## **OFFICIAL NOTIFICATION OF DECISION**

**Project# PR-2020-004457**  
**Application#**  
**SD-2023-00115 FINAL PLAT**

**LOT 22, UNIT 6, VOLCANO CLIFFS  
SUBDIVISION** zoned **R-A**, located on  
**QUIVERA**, containing approximately **7.8190**  
acres. **(D-9)**

FINAL PLAT QUIVIRA ESTATES	
DWG PATH: \\VERTICAL\SUBD\Volcano \Volcano Cliffs Unit 6 - LOT 22 BNDY-TOPO-REPLAT\QUIVIRA FINAL DRAFT.dwg QFS: JR/TIO DATE: 03/22/23 SCALE: 1"=50' CREW: LRC/CFS DRAWN: SLN JOB NO.: N942-03-930	1 of 3

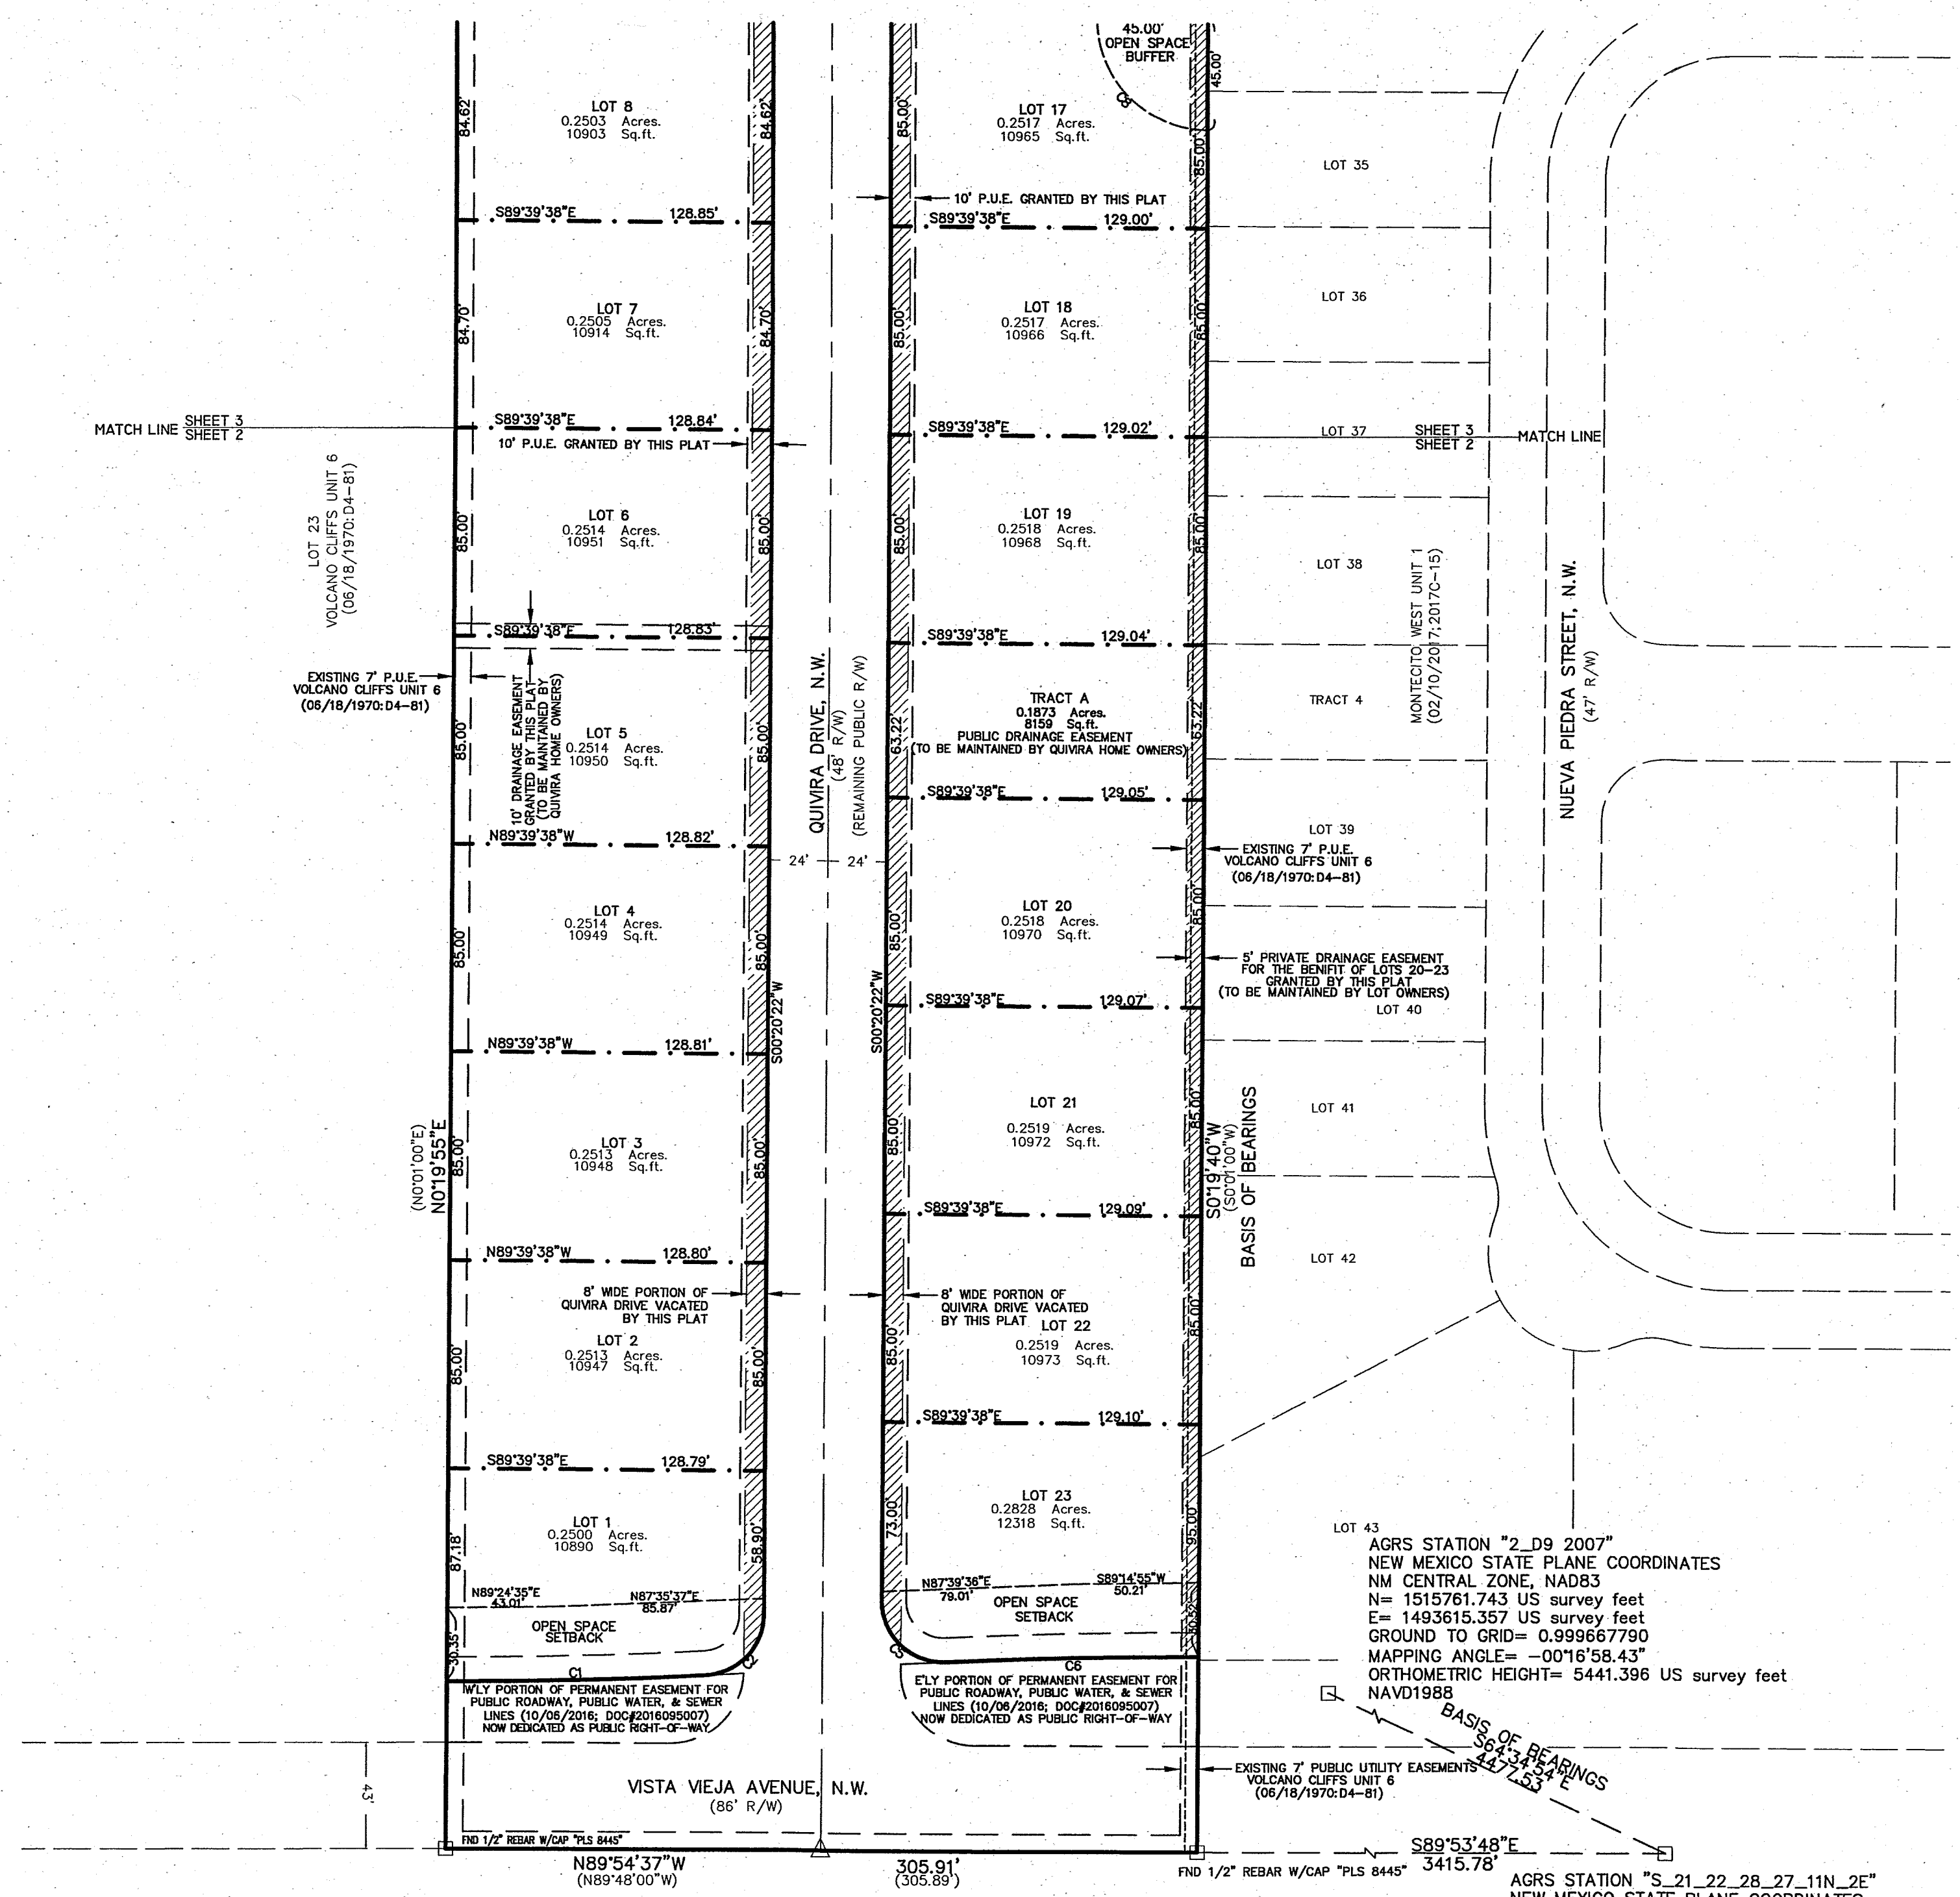
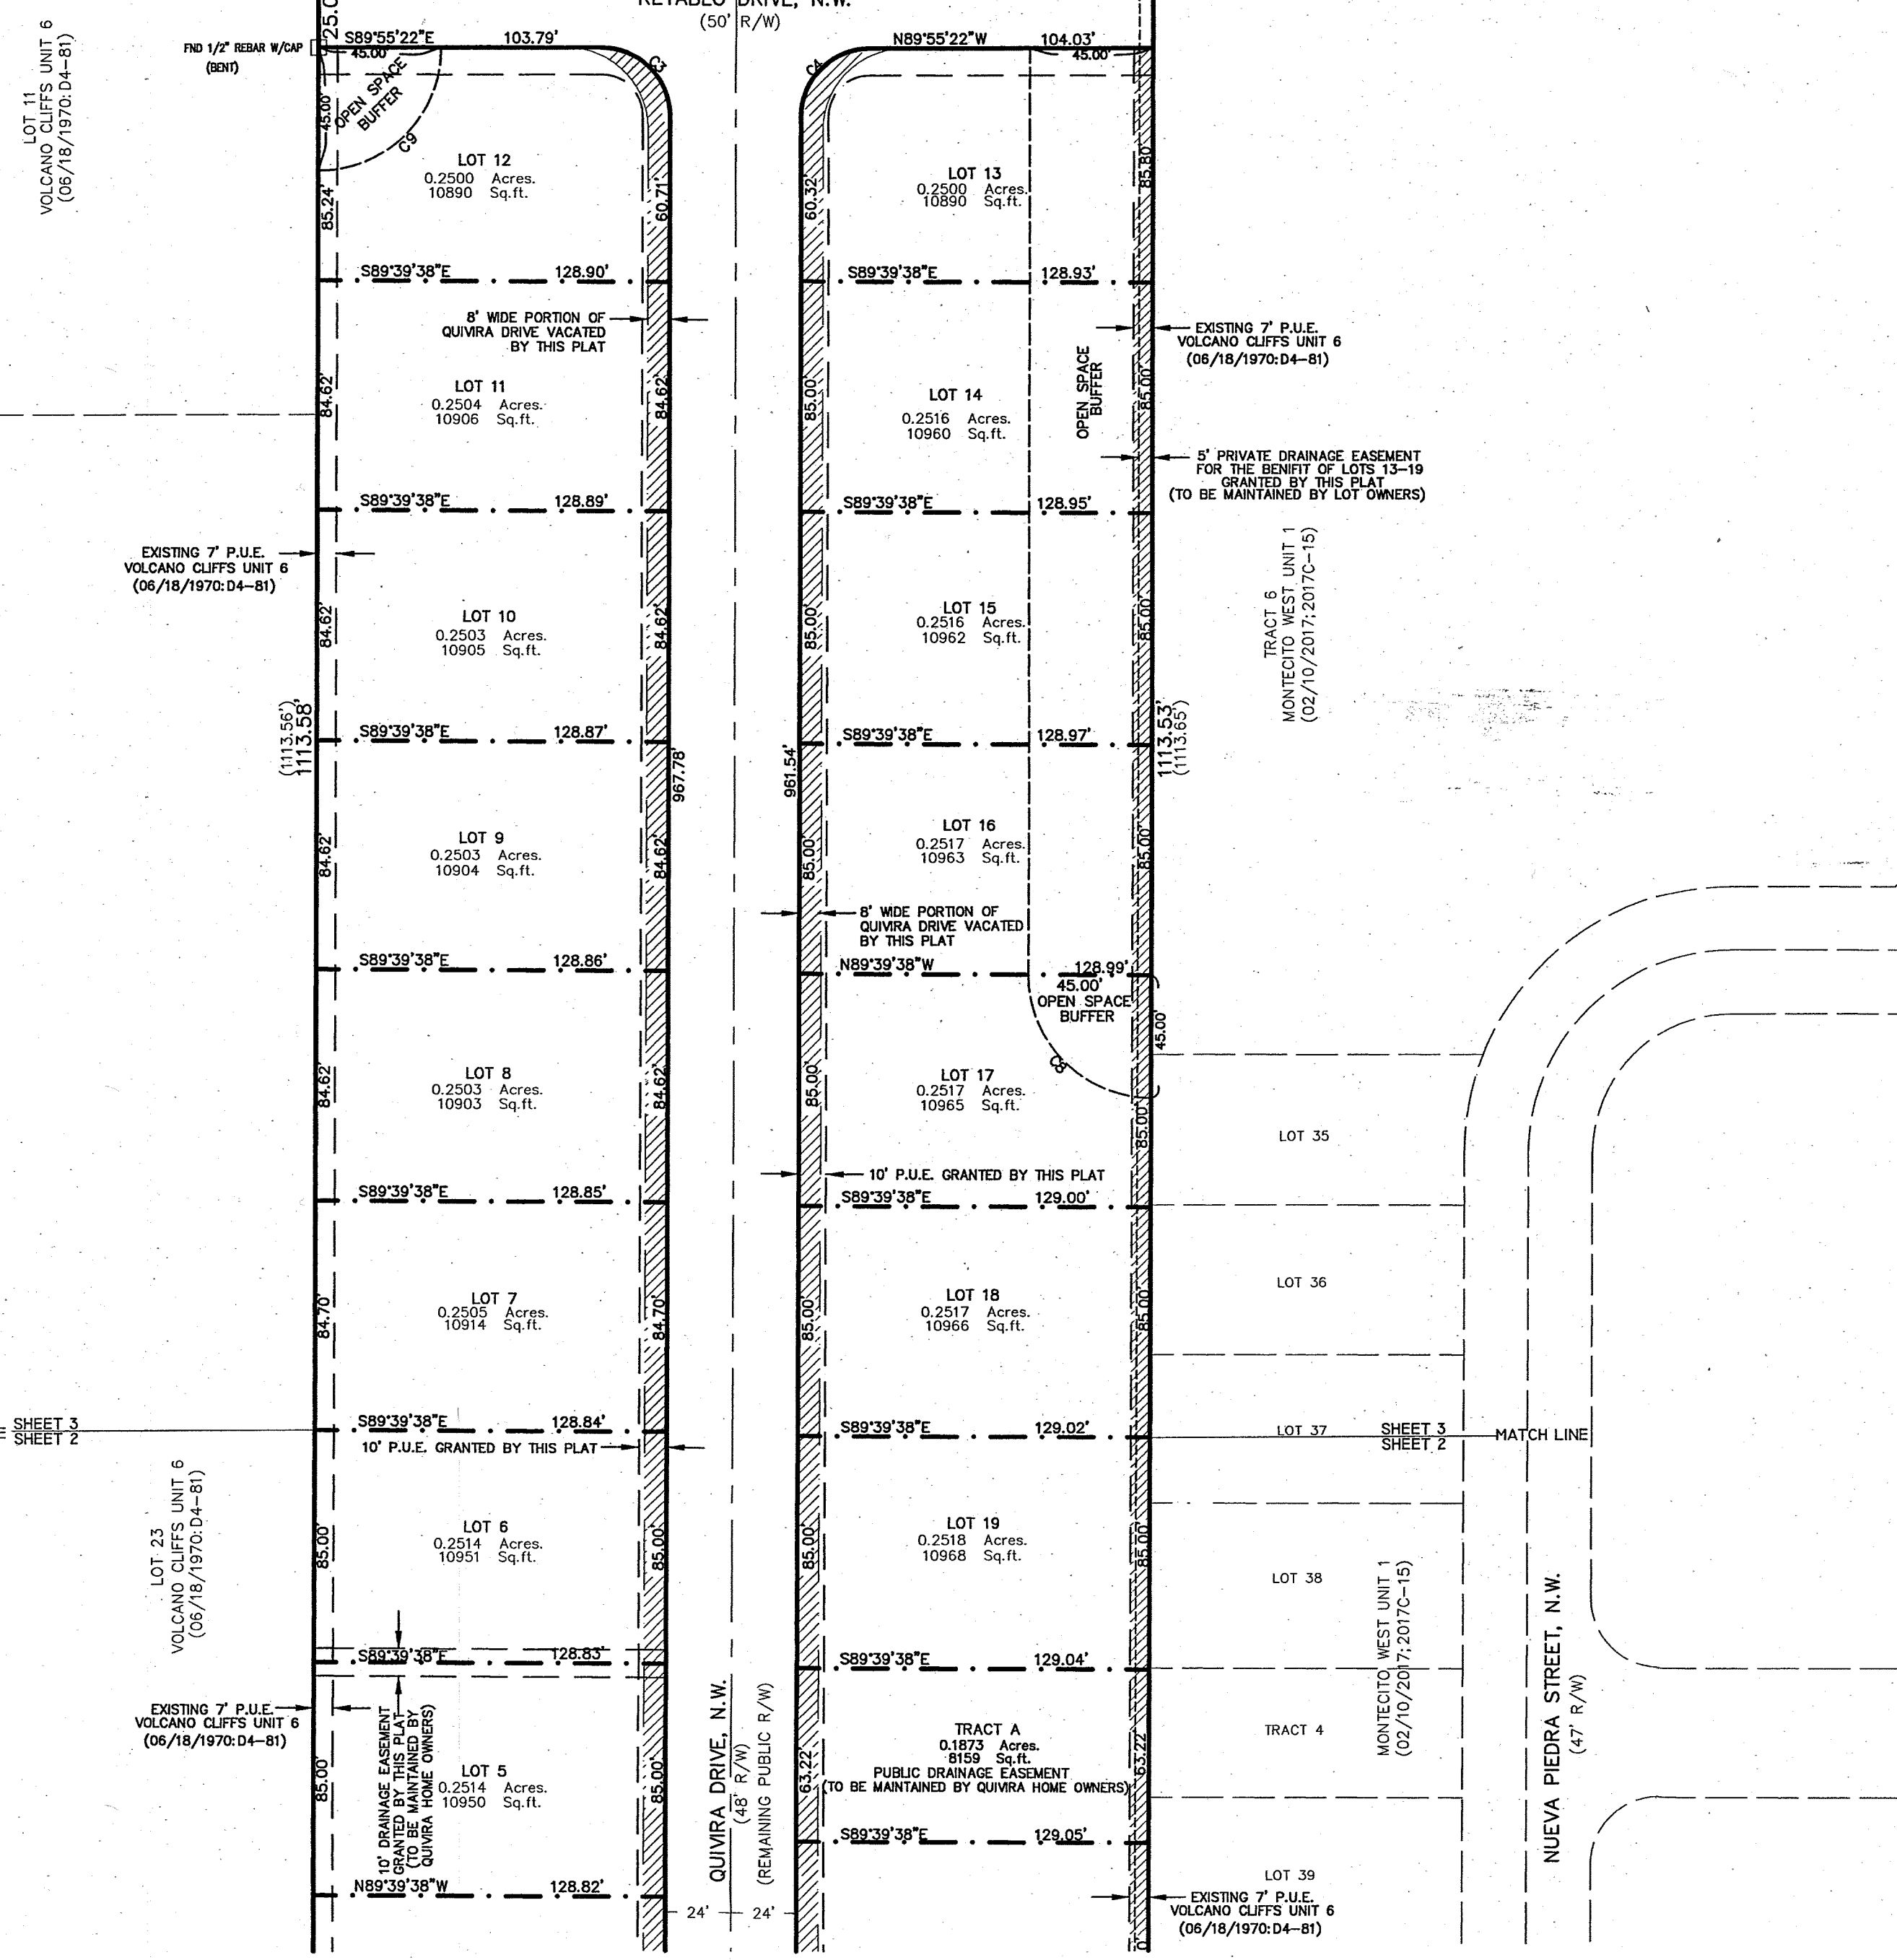
- a. A note added to the Plat indicating that the Open Space Superintendent must approve landscaping in all areas designated as Open Space Buffers.
- b. Project and application numbers must be added to the Plat.

- c. DXF file must be approved by AGIS and approval email submitted.
- d. DHO signature Block must include Hydrology and City Engineer Signature Lines.
- e. Correct the drainage easement on Lot 20 to 7-feet.
